CGS Review Comments
EP-24-0045 Grandview Reserve Phase 3
File No. PUDSP241
Portion of Sections 21, 22, 27, & 28 T12S, R64W, 6th P.M.
38.9906, -104.5552
Grandview Reserve Phase 3

Comments uploaded to El Paso County Development Application Review on 11/7/2024:

With this resubmittal, we reviewed the Geologic Hazard Evaluation and Preliminary Geotechnical Investigation (CTL Thompson, Inc., Revised October 7, 2024), Letter of Intent (HR Green Development, LLC, October 17, 2024), PUD Development Plan and Preliminary Plan (HR Green, October 17, 2024), Early Grading and Erosion Control Plan (HR Green, October 16, 2024), and other documents. CTL's report provides a valid description of surface and subsurface conditions and soil and bedrock engineering properties. CTL states on page 8, "The most significant hazard identified at this site is shallow groundwater." We offer the following comments and recommendations.

GRANDVIEW RESERVE PHASE 3 PUD DEVELOPMENT PLAN & PRELIMINARY PLAN

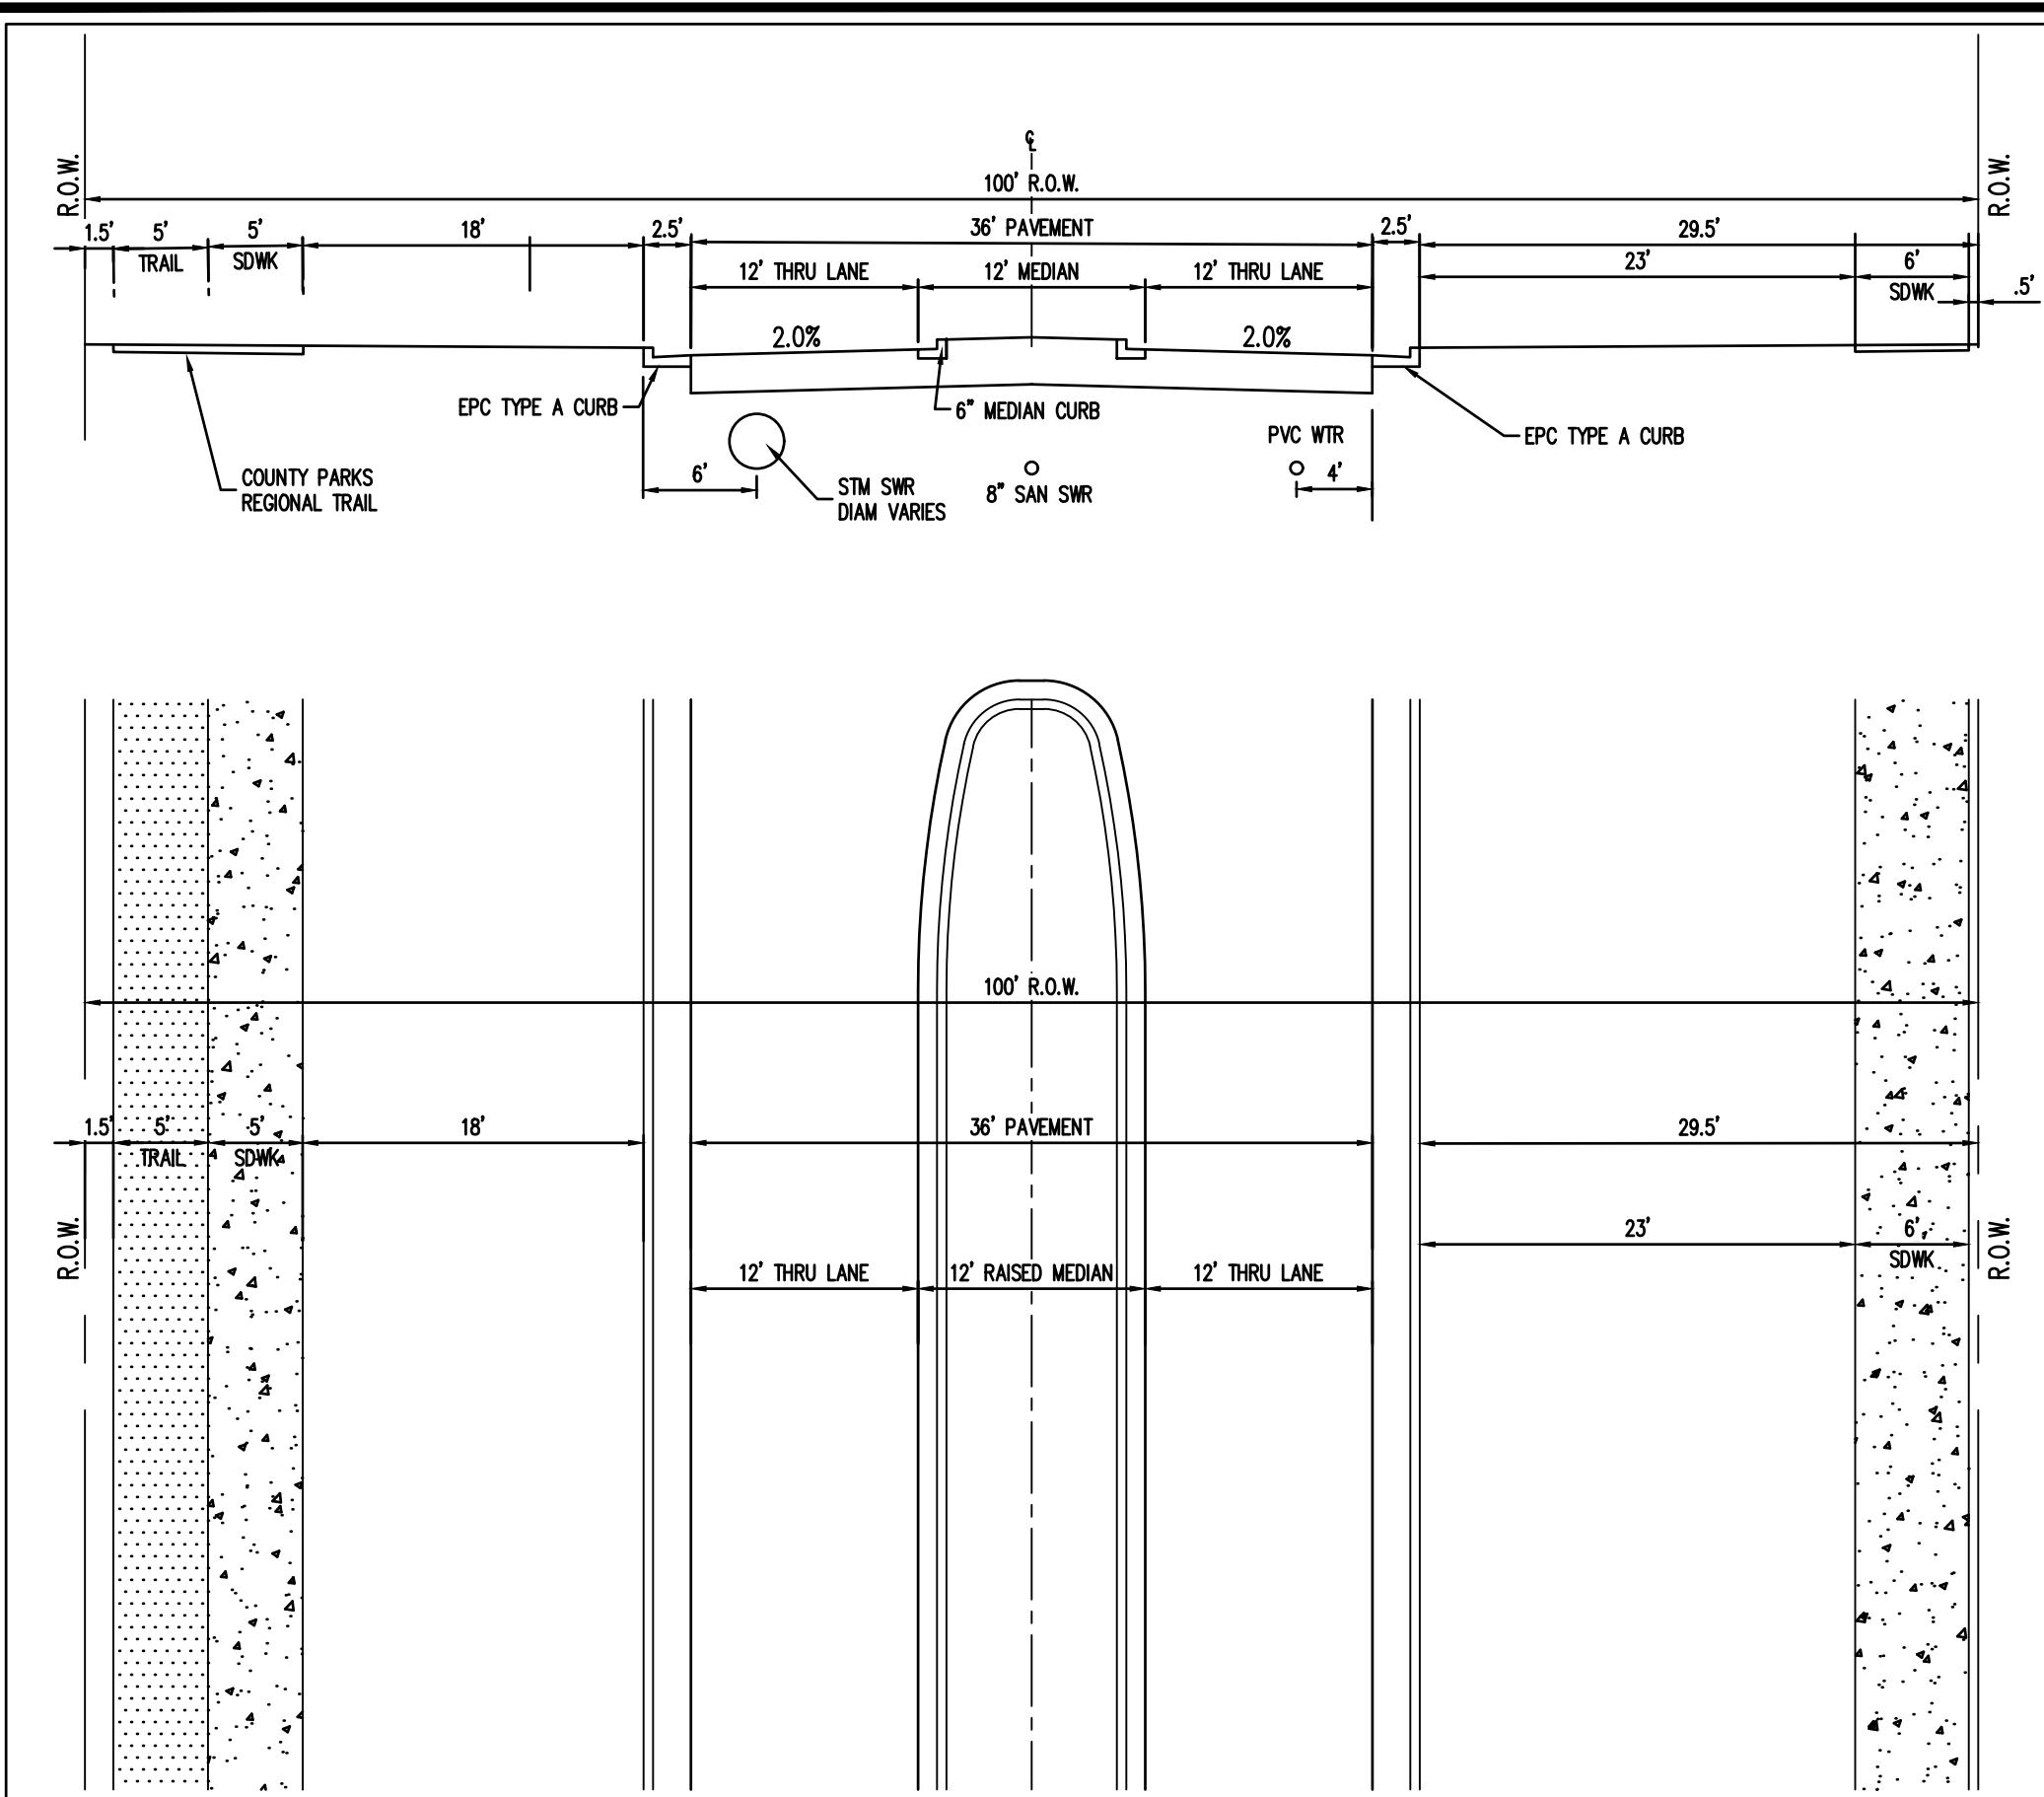
1. Based on the referral documents, the site is located within a designated FEMA floodplain (Map Numbers 08041C0556G and 08041C0552G, December 7, 2018) and plans are in process to establish new floodplain limits. The PUD Development Plan (Floodplain Notes, note 3) states, "Those lots either partially or entirely located within the current floodplain shall not be platted until the floodplain boundary revision process is completed effectively removing the floodplain limits from these lots," and note 5, "No structures or solid fences are permitted within the designated floodplain area." CGS concurs with the PUD Development Plan that no lots should be associated with the current floodplain. **CGS recommends establishing a setback from the flood hazard boundary to reduce hazards associated with floodwater inundation, erosion, and scour.** CGS looks forward to reviewing the preliminary plat application once the flood limits are approved/revised. No build areas should be added to lots that include hazards.

6. **CGS recommends that the geologic hazard note (Soil and Geology Conditions) on the preliminary development plan should be updated to identify lot numbers for the geologic constraints, specifically shallow groundwater.** This note should be incorporated into the preliminary and final plats going forward. No build areas should be added to lots with geologic hazards/constraints.

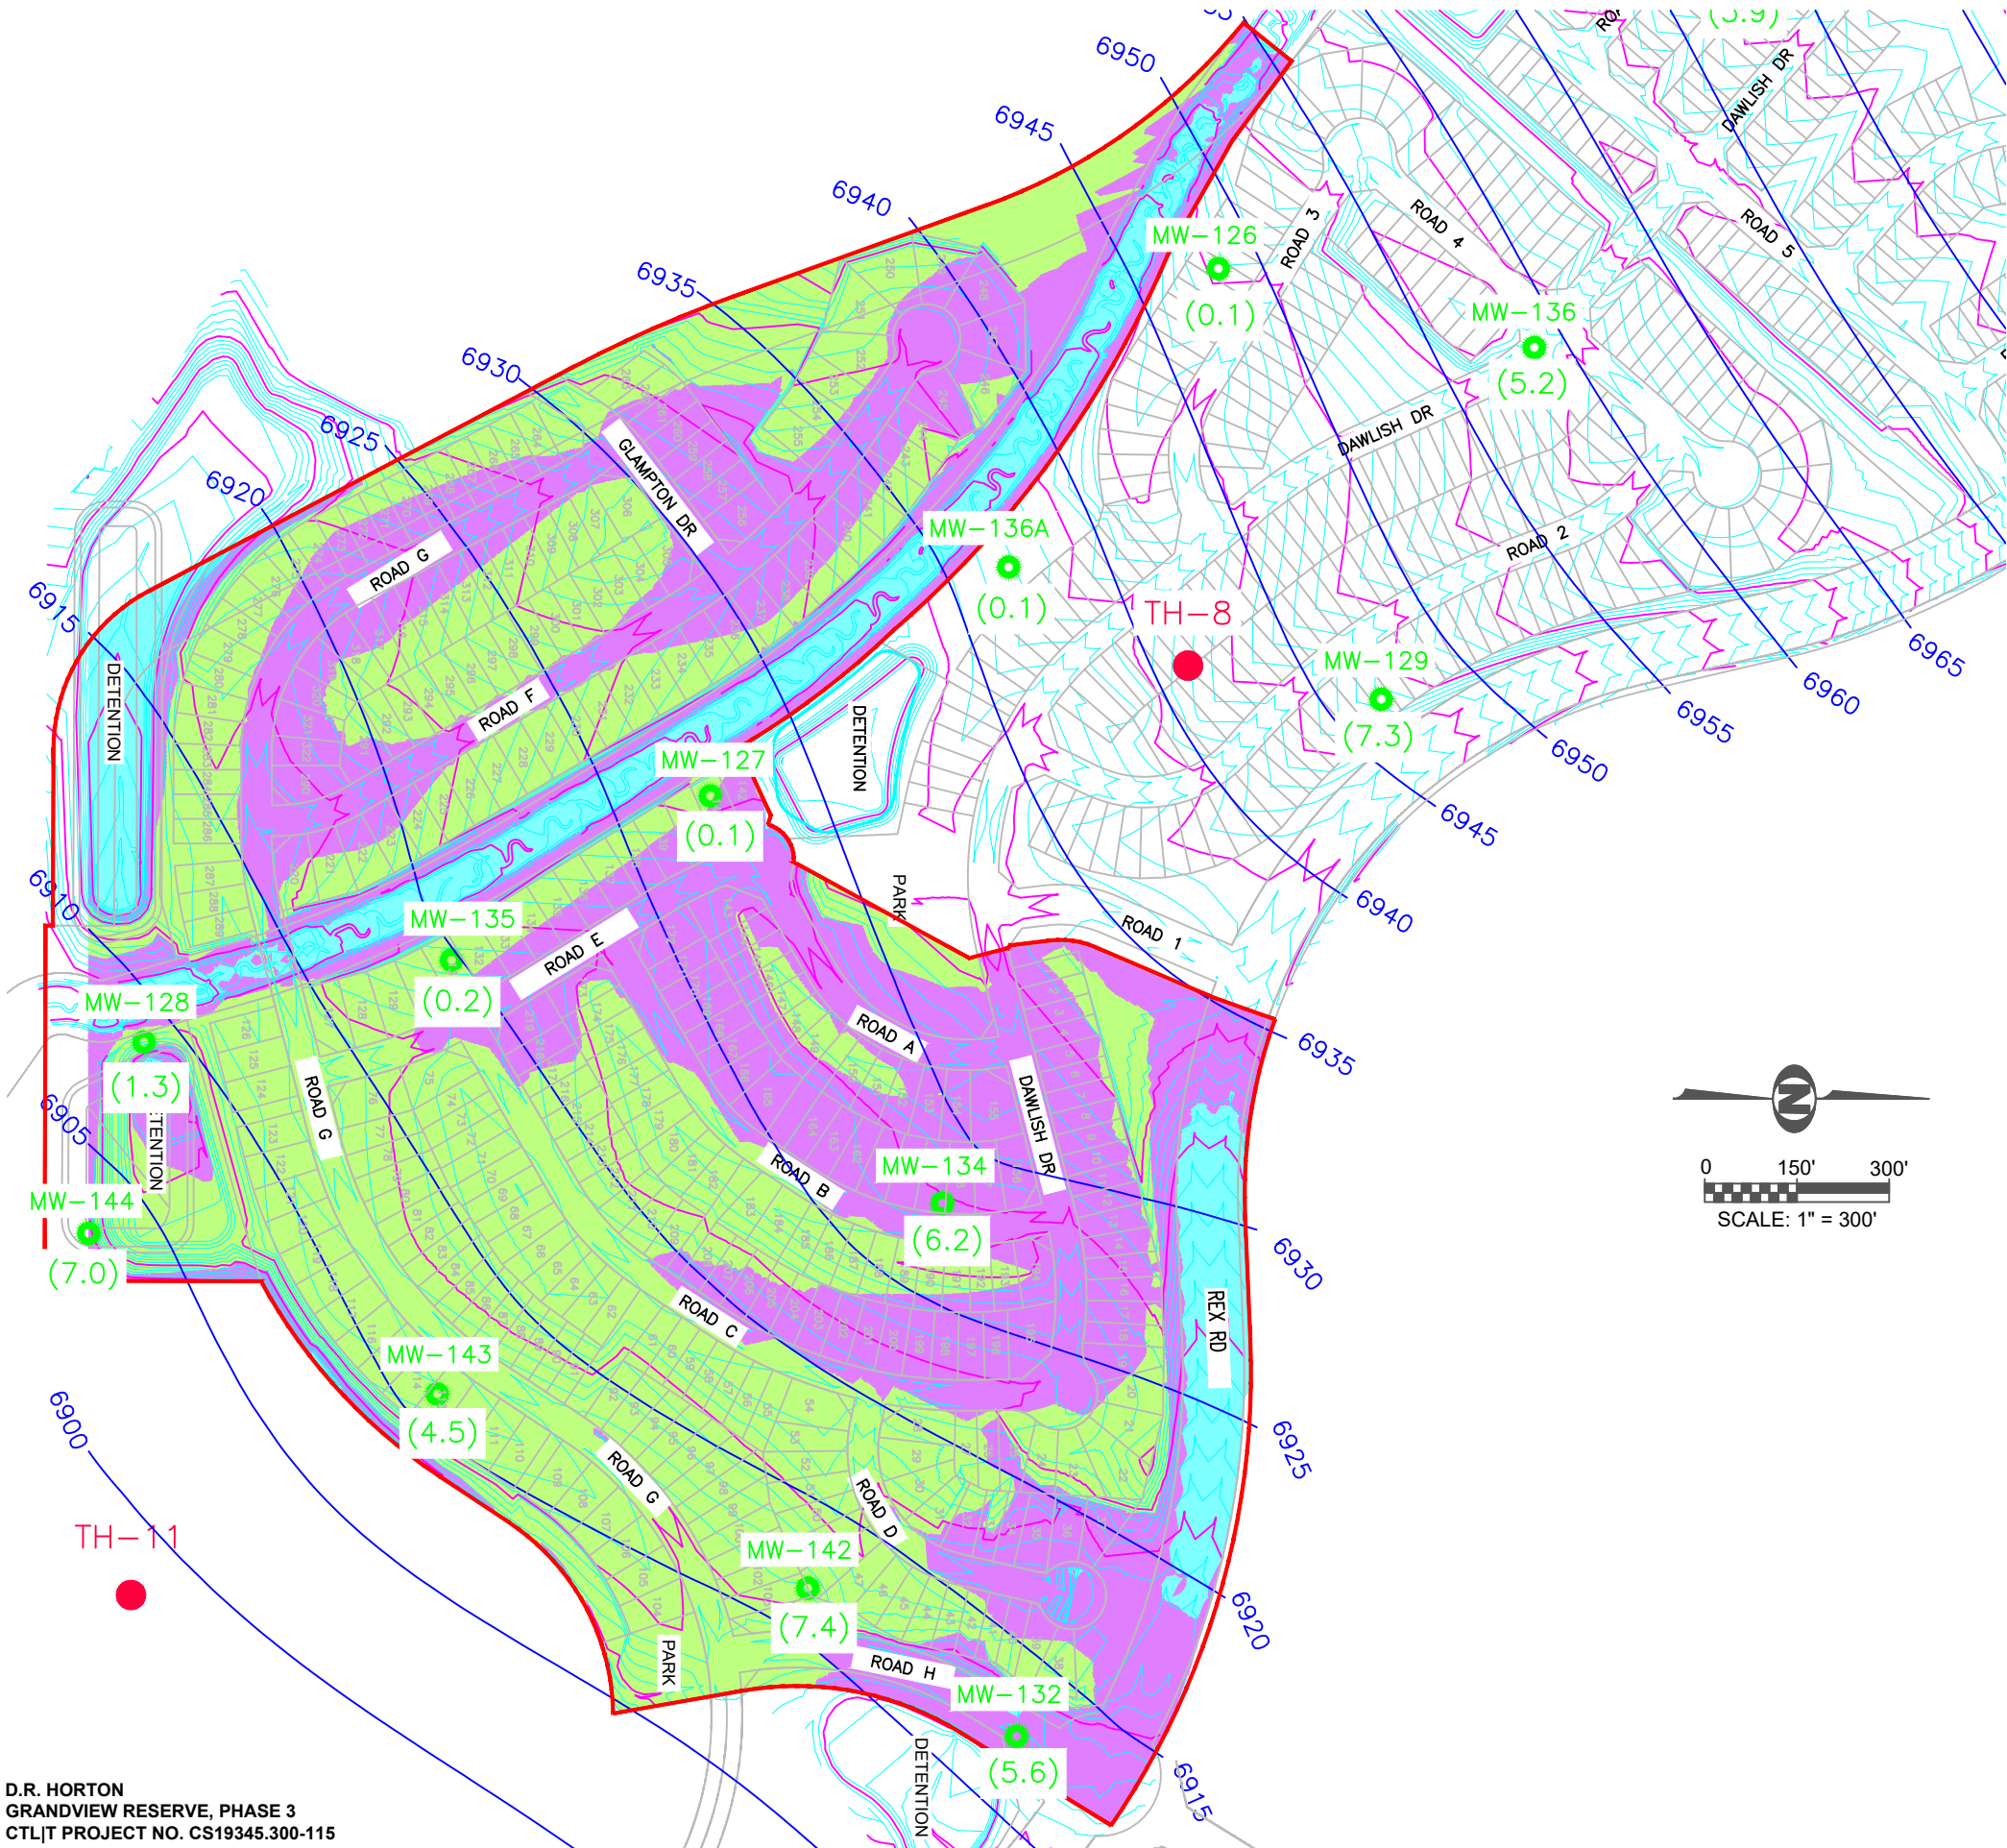
2. CGS commends CTL for installing monitoring wells within the site. From October 10, 2023 through October 3, 2024, measurements indicated groundwater depths between 0.1 and 14.1 feet. **Based on these updated groundwater levels for one calendar year, the groundwater ranges from at the surface to less than 9 feet below existing grades.** Proposed grading plans still need to be finalized; however, it does not appear that proposed grades will result in significant fill across the site to mitigate shallow groundwater.

Additionally, CTL states (page 3), "Lots where groundwater is expected to be within 10 feet of the proposed surface are restricted from basement construction." CTL's revised report appears to allow some flexibility for basement feasibility for lots where groundwater is greater than 10 feet below the proposed grades. CTL does not provide specific quantities of cut/fill in their report. **CGS recommends that a cut/fill exhibit be included in CTL's study, illustrating the proposed grades and monitoring test holes showing groundwater levels.** CGS agrees with the letter of intent that below-grade levels should not be allowed within the Grandview Reserve Phase 3 development due to the shallow groundwater levels.
